12 January 2018

Your Ref: SSD 8344

**K-6 Public School – Nos. 120-126 Hezlett Road, Kellyville**

Original Size **A1** Drawing No: **21-26108-KN-SD-CI-1011** Rev: **F**

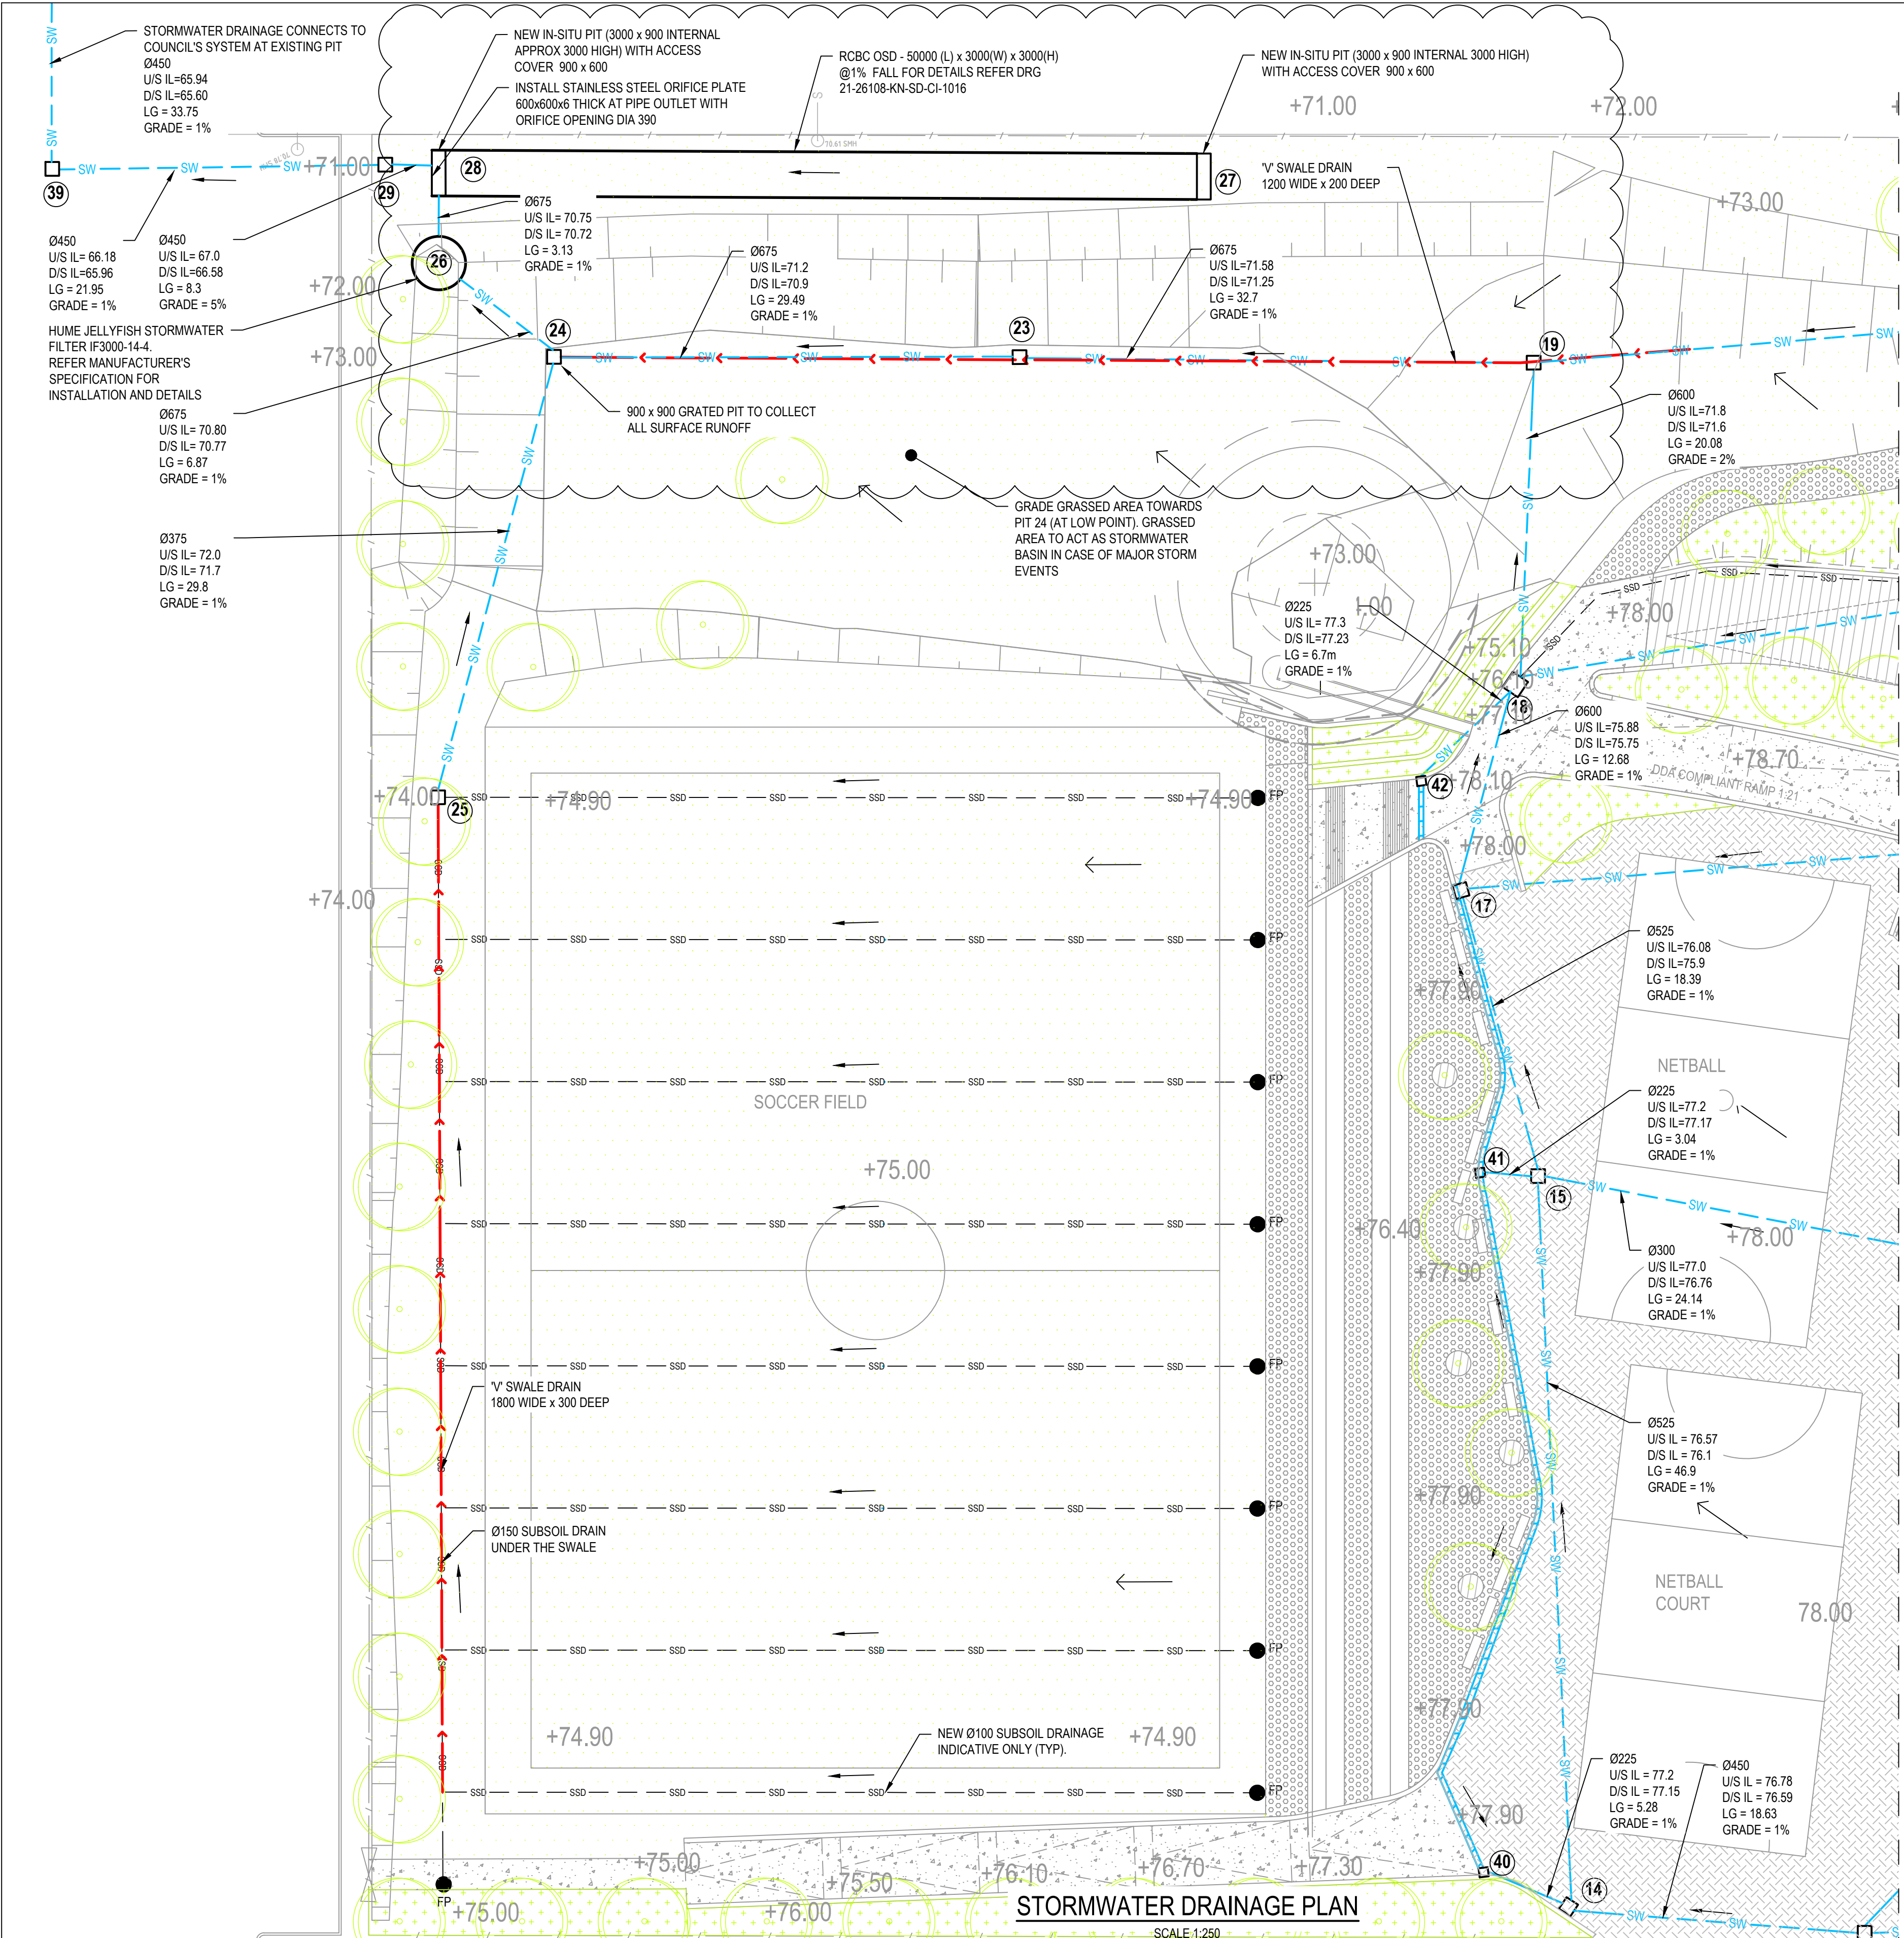
- The stormwater report refers to 900 cubic metres of OSD storage however the stormwater plan shows only 634.5 cubic metres of storage.
- The stormwater report refers to a 12.5 cubic metre rainwater tank however the stormwater plan refers to a 22.5 cubic metre rainwater tank.
- The stormwater plan still does not show what roof areas are intended to drain to the rainwater reuse tank.
- The grassed swales are still not shown on the stormwater plan (contrary to the response to submissions letter).

STORMWATER DRAINAGE PLAN

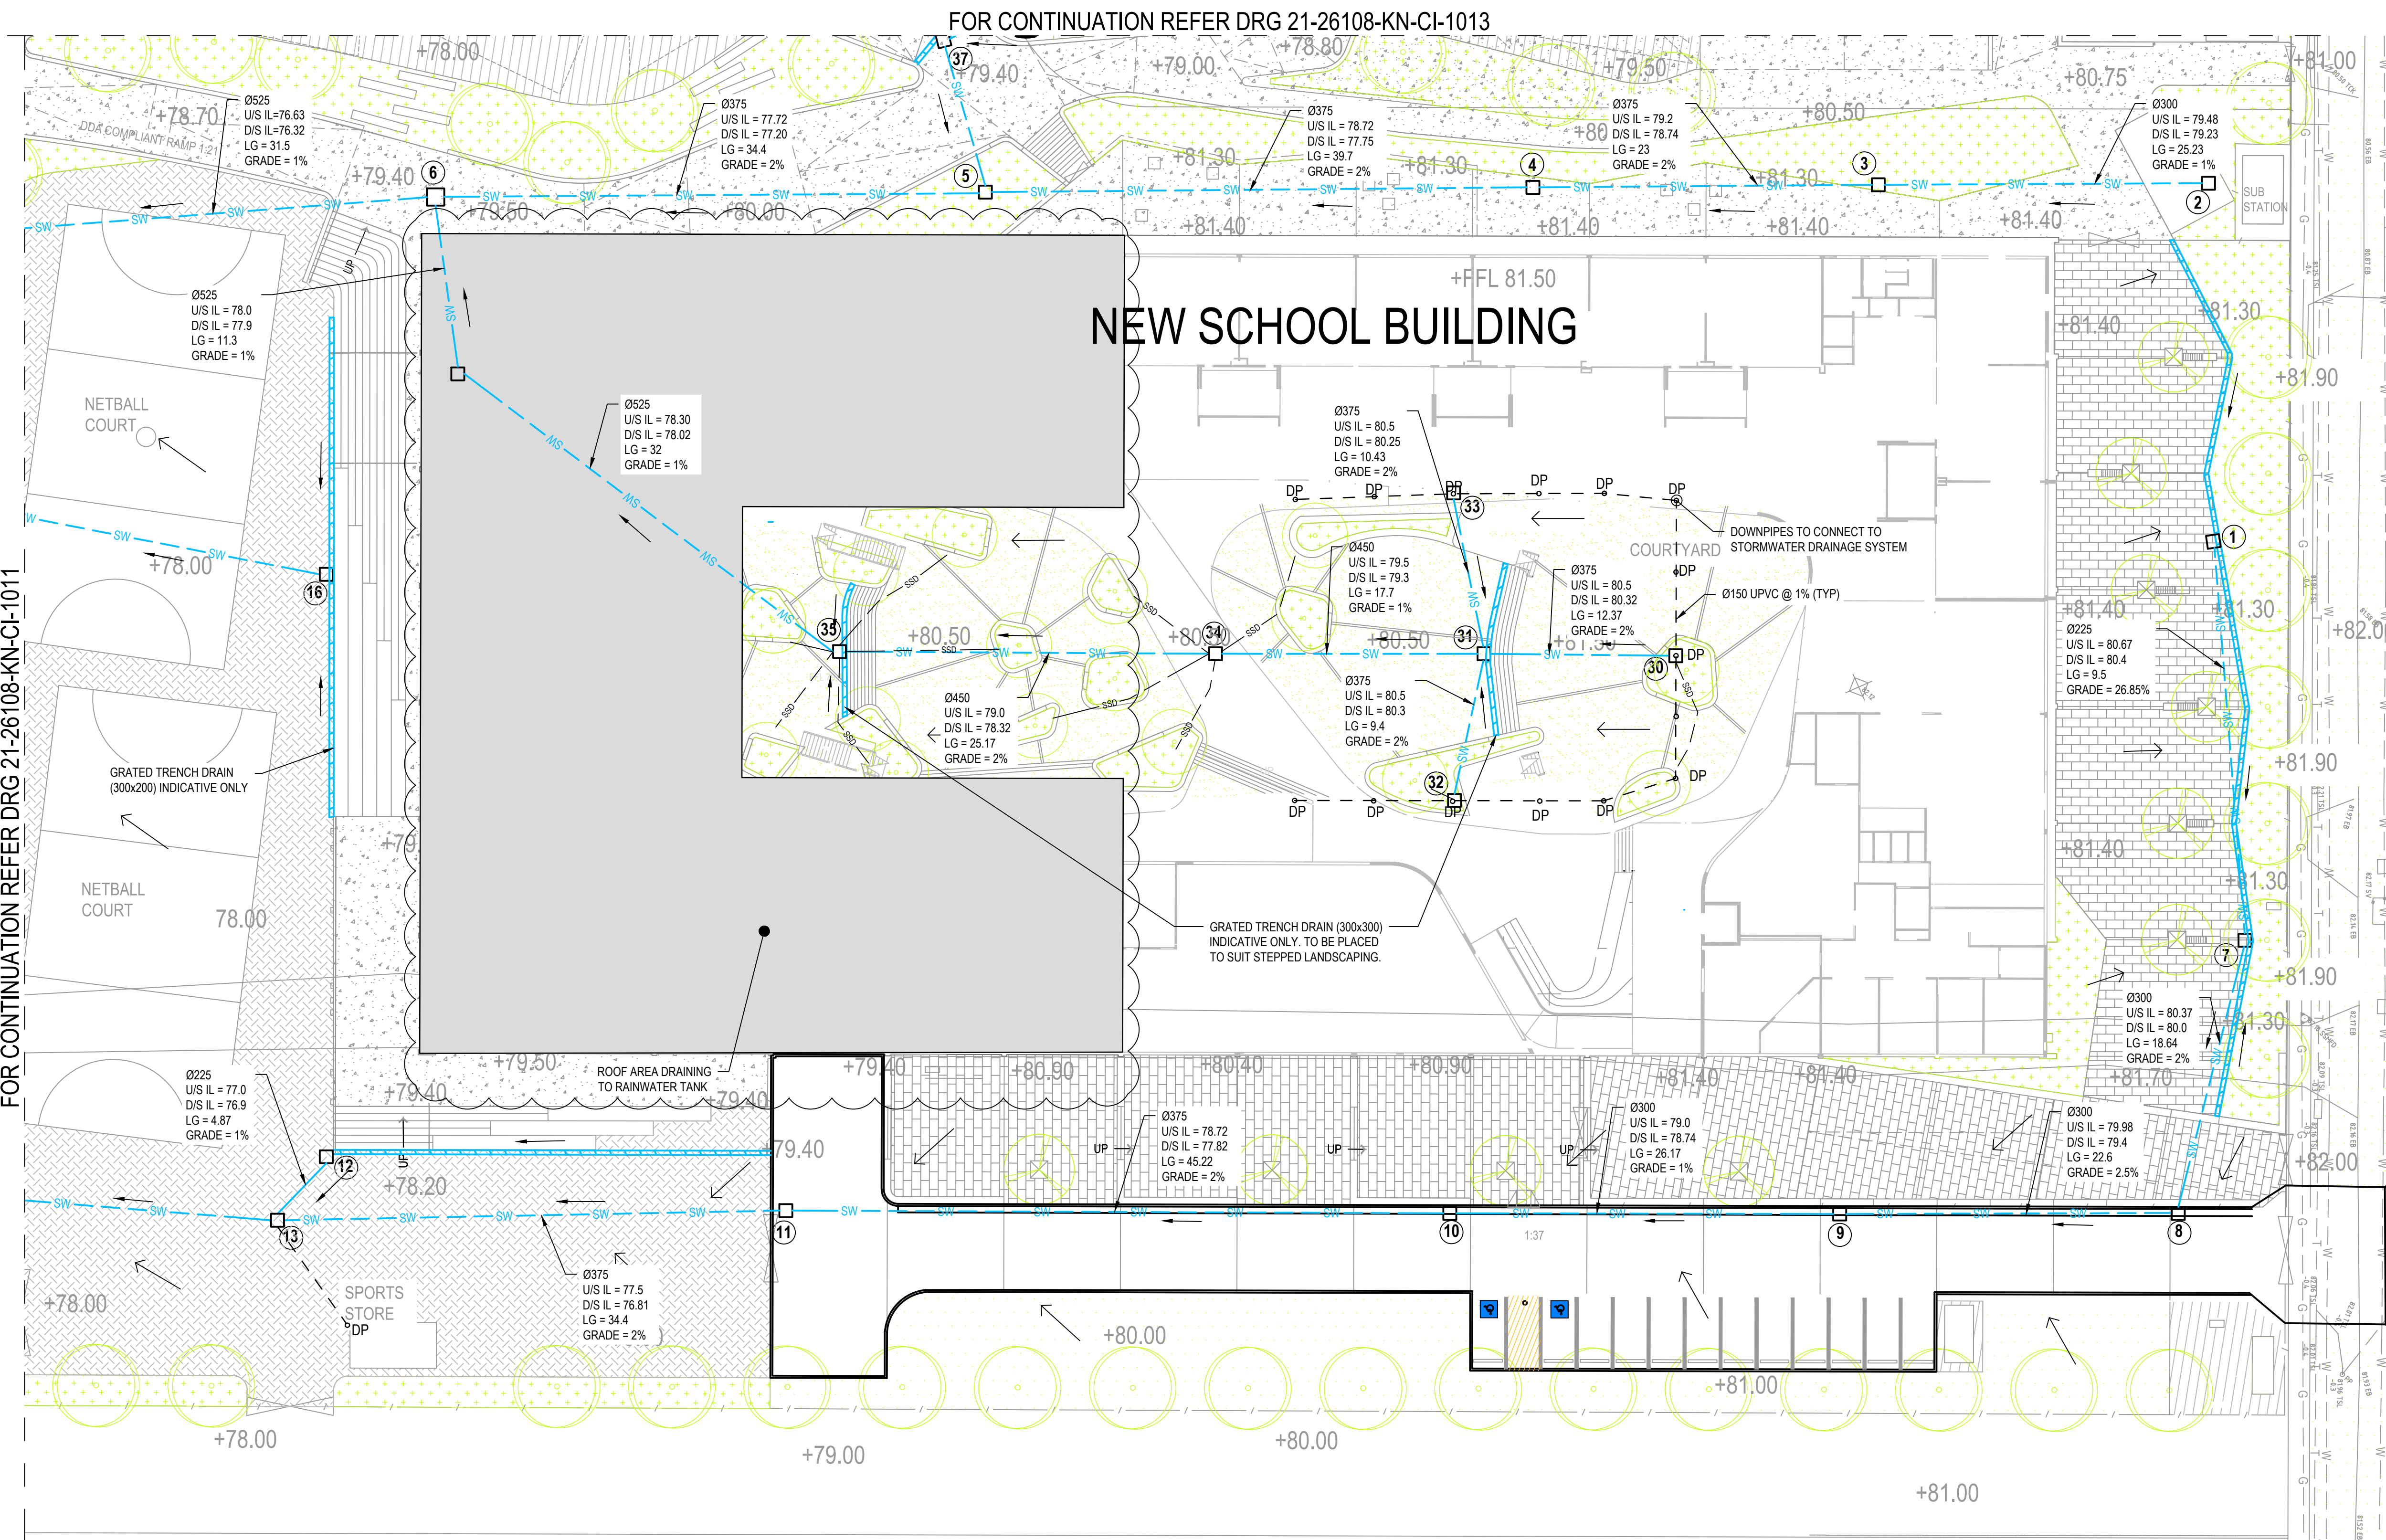
The stormwater plan does not include the detail previously requested for the stormwater connection to Hipwell Avenue, however noting that these works within an existing dedicated public road will require separate approval from Council under the Roads Act 1993 this matter could be dealt with post determination if needed:

*The existing pits and pipes need to be identified via survey and reflected on the plans to show that the pipe sizes and levels included on the design will actually work.*
